From: Paul Scamans <Paul.Scamans@arun.gov.uk>
Sent: 21 December 2016 14:59
To: [REDACTED]
Subject: 15 Queen Lane, Arundel, West Sussex

Further to your letter dated 2nd December and your submission of additional information on 20th December I write to confirm the following.

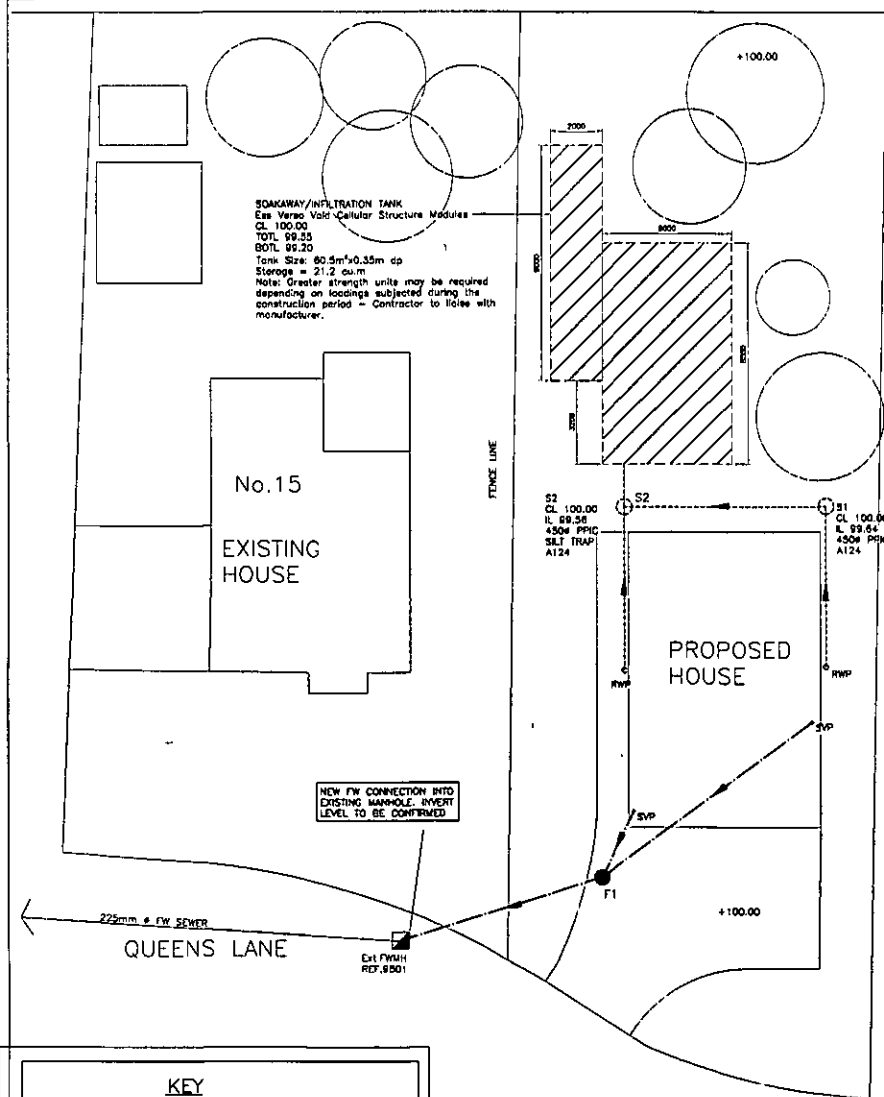
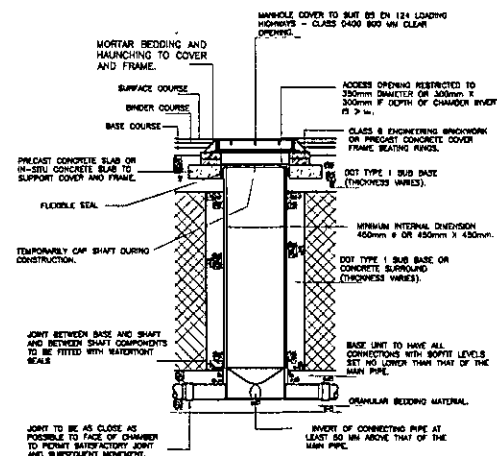
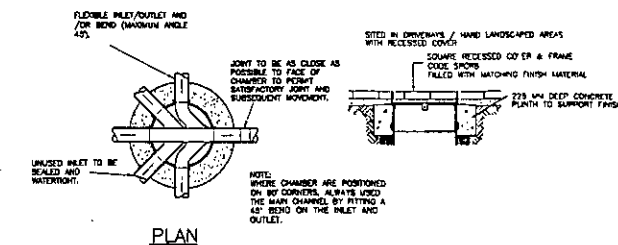
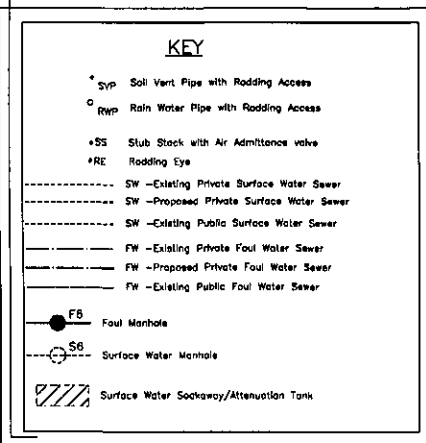
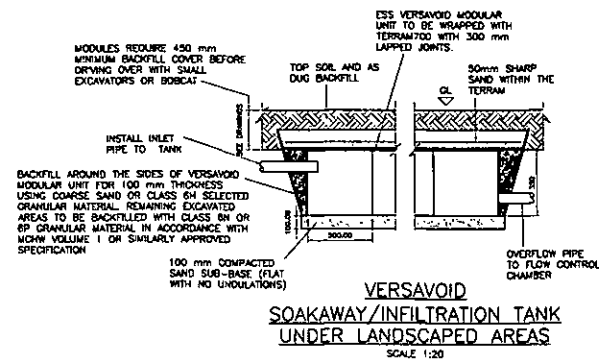
The assertion by your drainage engineer that a soakaway is not an appropriate surface water drainage solution in the alluvial flood plain of the River Arun is entirely consistent with our understanding of the local area. Any surface water drainage discharging to a combined foul drainage system should do so via a trapped gully.

The water authority will reserve the right to give consent, but once consent has been given this will satisfy the Building Regulations in terms of demonstrating that an appropriate system of surface water drainage has been provided to the site. Hopefully this should also satisfy any planning conditions.
